From: Sarah Smith
Sent: 27 February 2012 10:55
To: Planning
Subject: FW: Splashlands Highways comments

Subject: Splashlands

Project:
STANBOROUGH PARK
SPLASHLANDS
PHASE 2
Drawing Title:
PROPOSED WATER PLAY PARK
BARGE AREA, VIEWING PLATFORM,
BOUNDARY FENCE & CHANGING HUT DETAILS

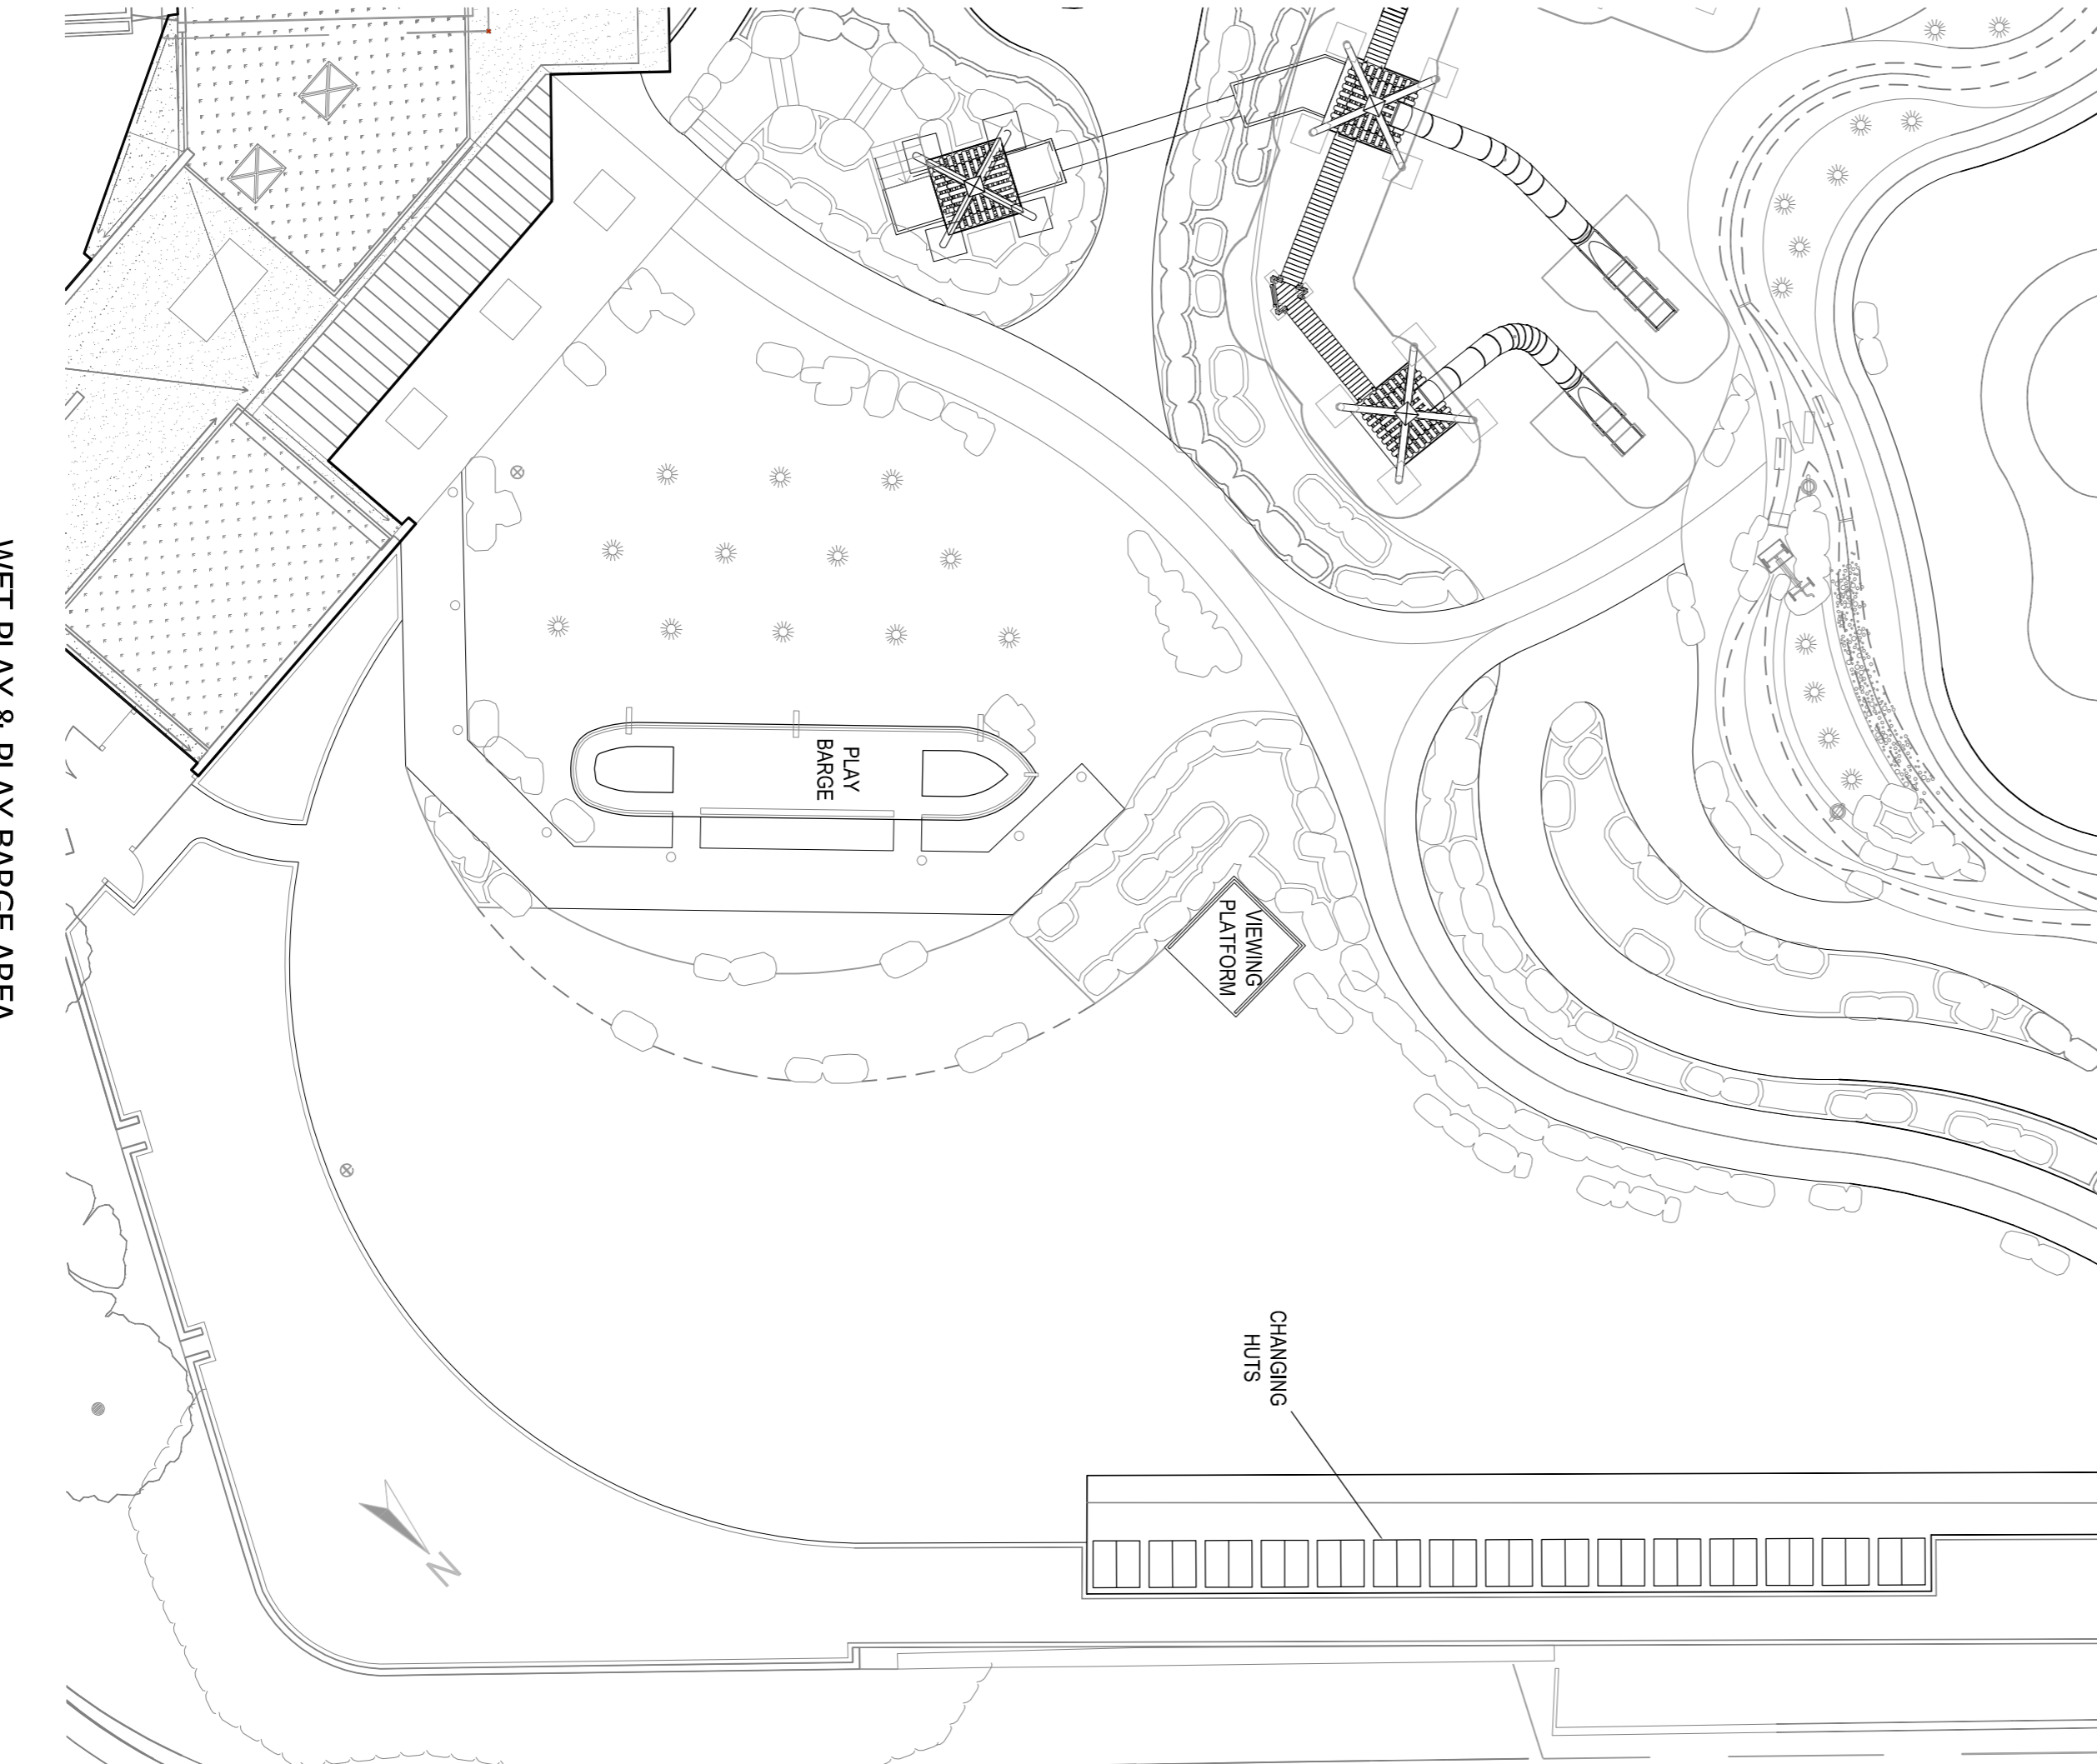
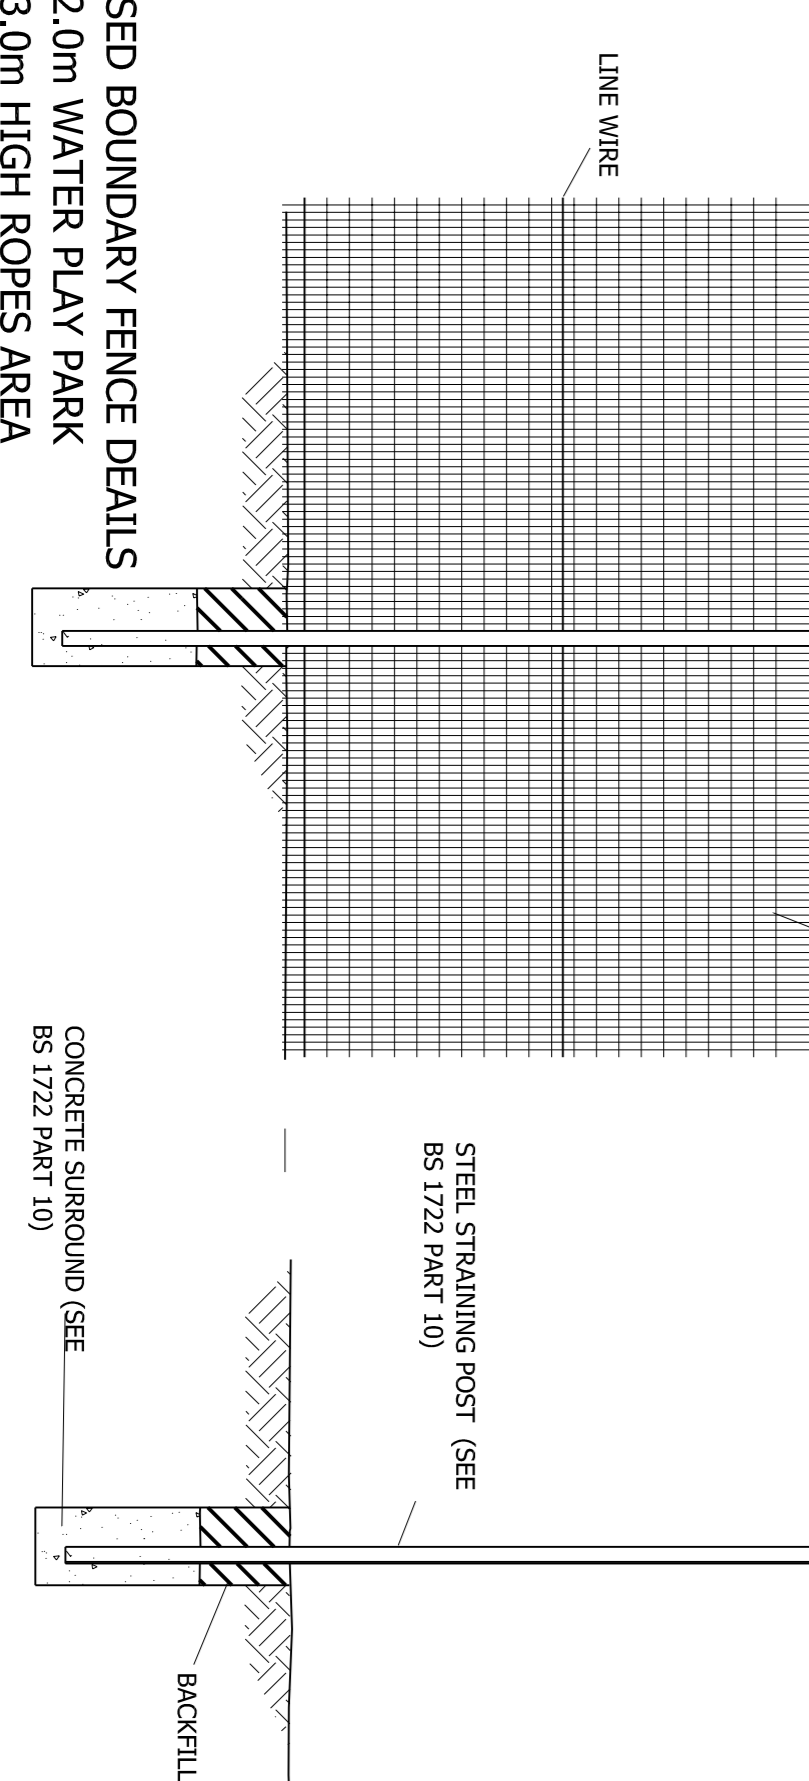
--> There are a number of existing plans which have not been amended to show the alterations proposed on the plans that were most recently submitted. For example the height of the fence around the high ropes area which has been reduced on the most recent submitted plans, the bark mulch proposed on the ground which has altered from hardstanding and the tunnel proposed between the pyramid towards within the wet play area.
